**City of Portland, Maine - Building or Use Permit Application**

Permit No: 02-1025	Issue Date: <b>SEP 12 2002</b>	CBL: 337 C059001
-----------------------	-----------------------------------	---------------------

**Proposed Project Description:**  
Removal of existing deck - rebuild new 9' X 10' deck in same footprint

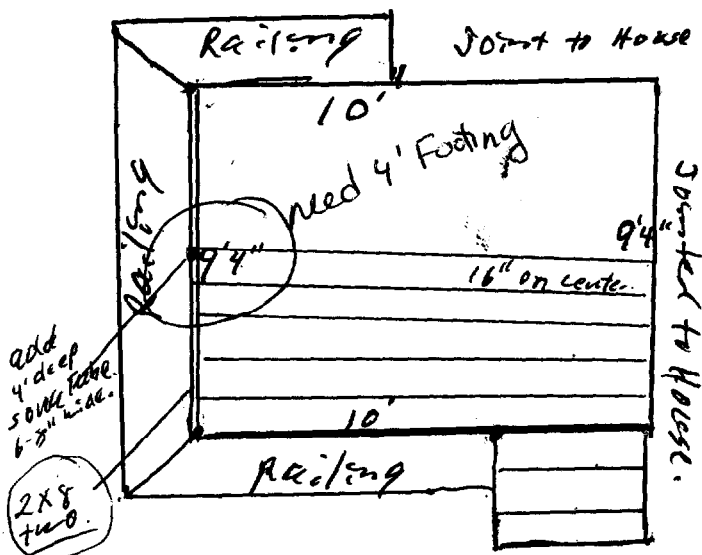
Need to add 4' ceiling of outside rim to decrease span of girder
